Development Facilitation Team (DFT) – Review Comments

DRB Project No: PR-2020-003485 Date: 04/12/2023 Agenda Item: #2 Zone Atlas Page: J-14

Location: 401 LOMAS BLVD NW between 4th ST and 5th ST

Application For: SD-2023-00065-VACATION OF RIGHT-OF-WAY (DHO)

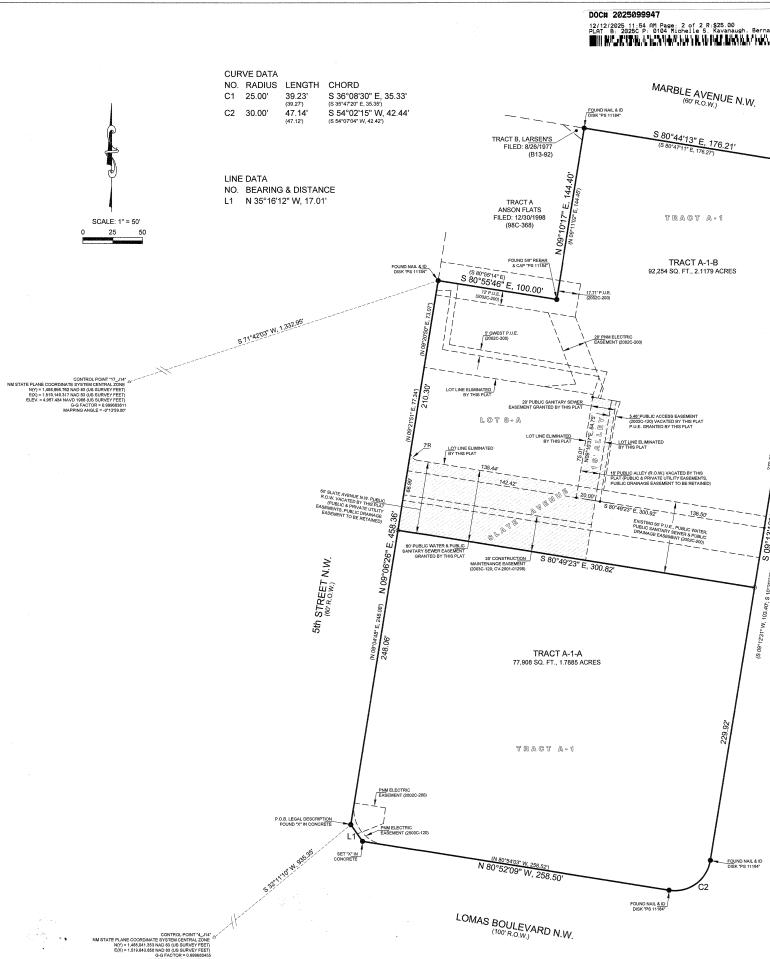
1. Coordinate with 811 and provide an exhibit showing the public water and sanitary sewer infrastructure that is within the corridor proposed to be vacated.
2. There is an existing water and an existing sanitary sewer within the public right-of-way that will require proper access to operate and maintain.
3. Provide the plat or proposed lot consolidation to demonstrate the final layout. The infrastructure on-site will require proper easement and surface access.
 - a. A 25' min easement is required for two public lines.
 - b. The easement corridor must be accessible for operation and maintenance.

1. This corridor has an existing public sanitary sewer line that must have a public easement
2. A minimum 20' easement must be in place for the existing line.

- Hydrology has no objection to the Vacation of the Public Right of Way (16' Alley and 60' R.O.W. of Slate Road).
- Prior to platting, Hydrology will need some sort of drainage exhibit with the current drainage patterns. Public Drainage Easements over the vacated 16' Alley and 60' R.O.W. of Slate Road may be needed.

RIGHT-OF-WAY | <ul style="list-style-type: none">• City Hydrology has indicated that there is drainage infrastructure in the Slate Ave. ROW. A public drainage easement will need to be granted for access and perpetual maintenance of the drainage infrastructure before or at the time of ROW vacation. Alternatively, a private drainage easement may be granted for the drainage infrastructure and maintenance of that infrastructure would be subject to a covenant with the City of Albuquerque. |
